CITY OF ALBUQUERQUE

Re: Pulte APS Development
Traffic Impact Analysis (J08D003B, TRANS-2025-00009)
Initial Submittal Dated January 20, 2025
Via email: cvermillion@bhinc.com

The subject initial Traffic Impact Analysis (Study) received on January 30, 2025, has been reviewed by the City of Albuquerque Planning Development Transportation Section and provides the following comments.

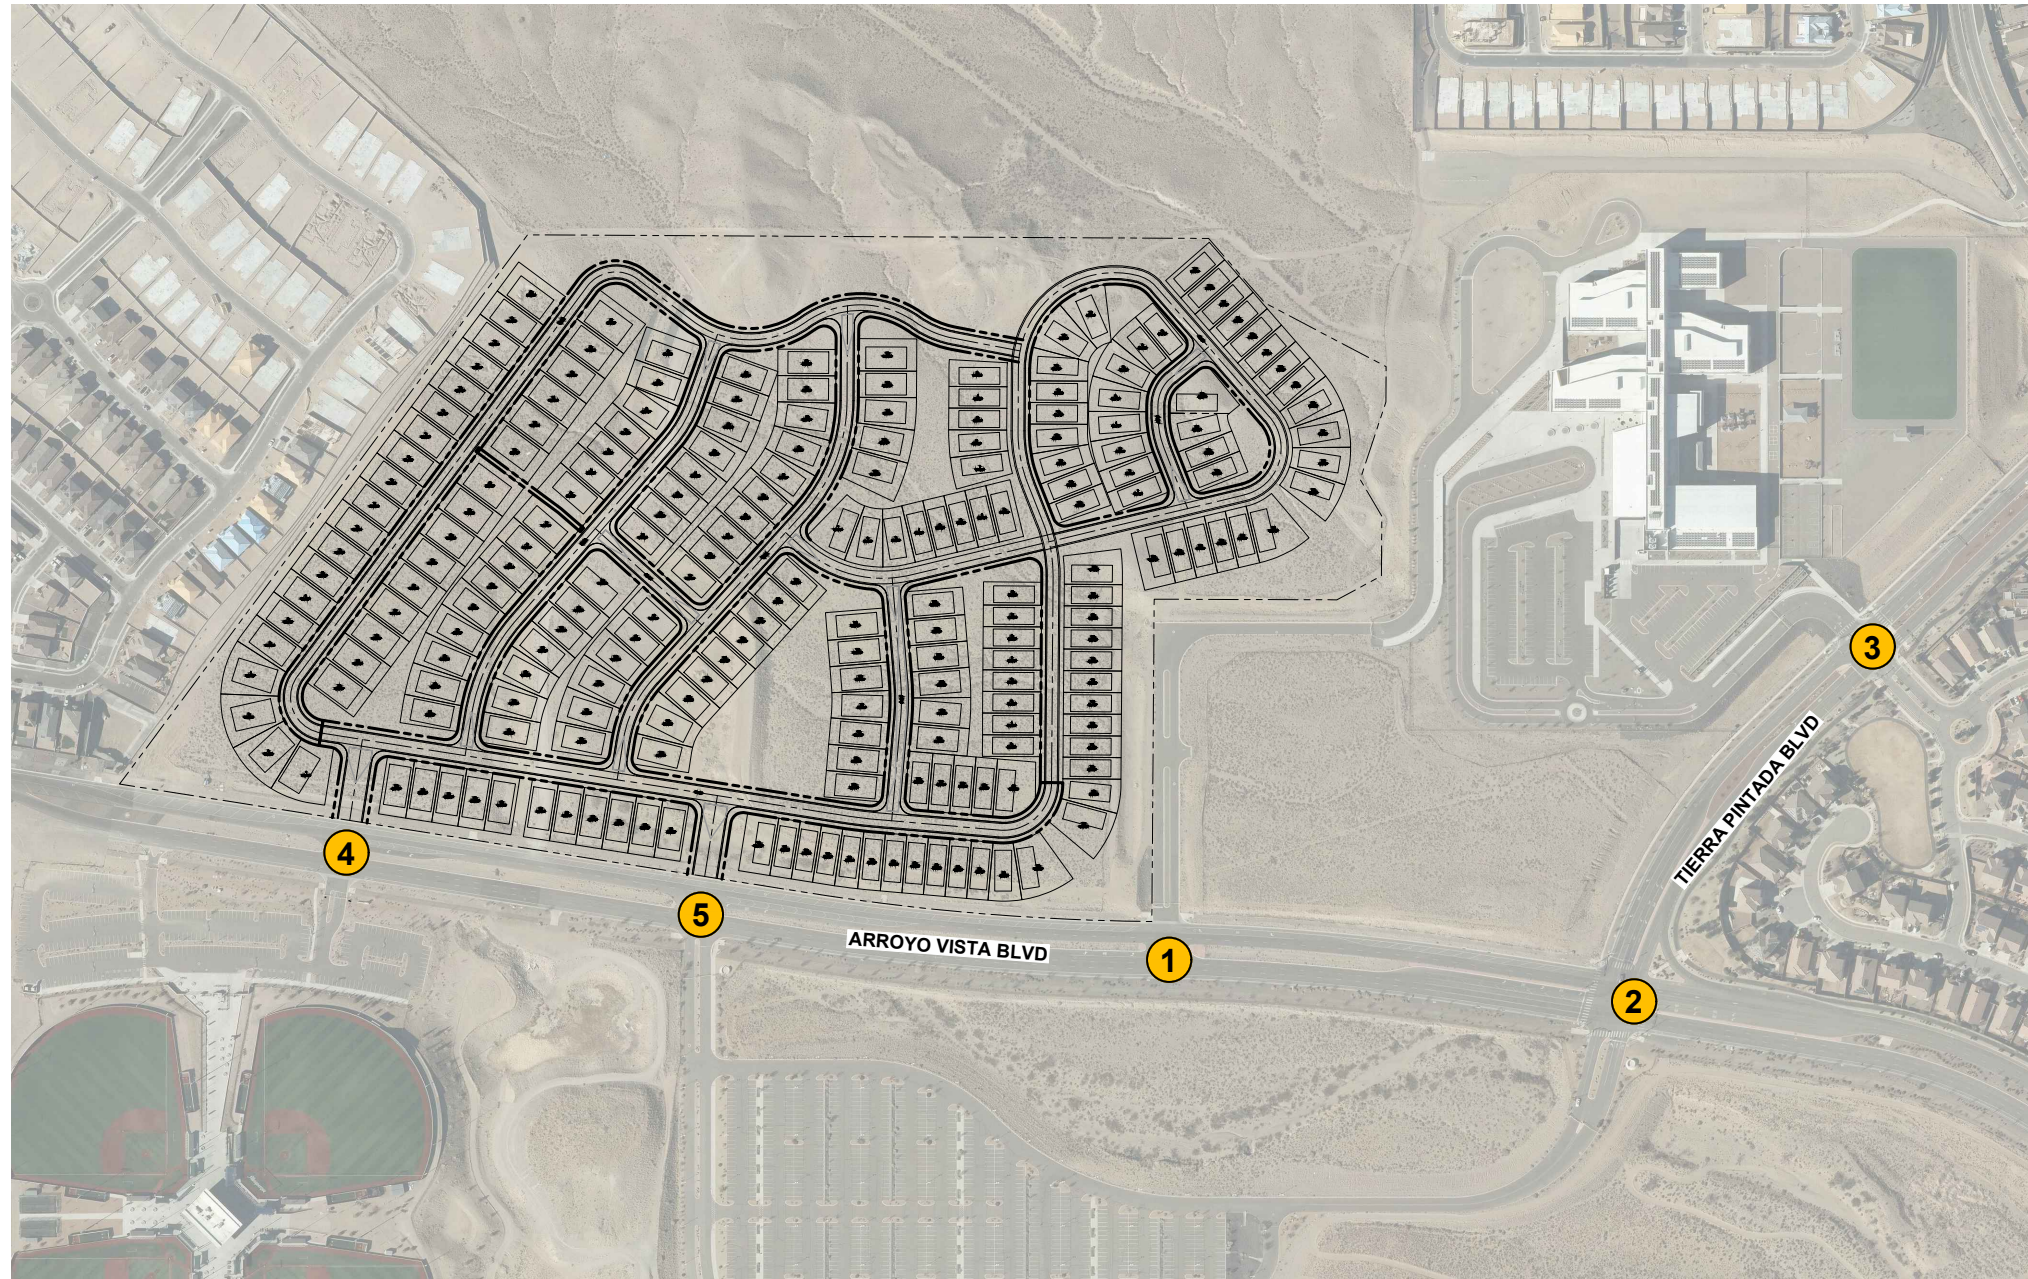
1. The residential trip distribution shown on Figure 3 (p. 13) at Intersections 2 and 3 doesn't match very well with the existing trip distribution shown in Figure 2 (p.10). More traffic is making the EBL movement at Intersection 2 and traffic is making a NBL movement at Intersection 3. Trip distribution for Pulte APS would have a similar trip distribution as Pulte Inspiration/existing. Please revise the trip distribution at Intersection 2 and 3 to more closely match the trip distribution in Figure 2.
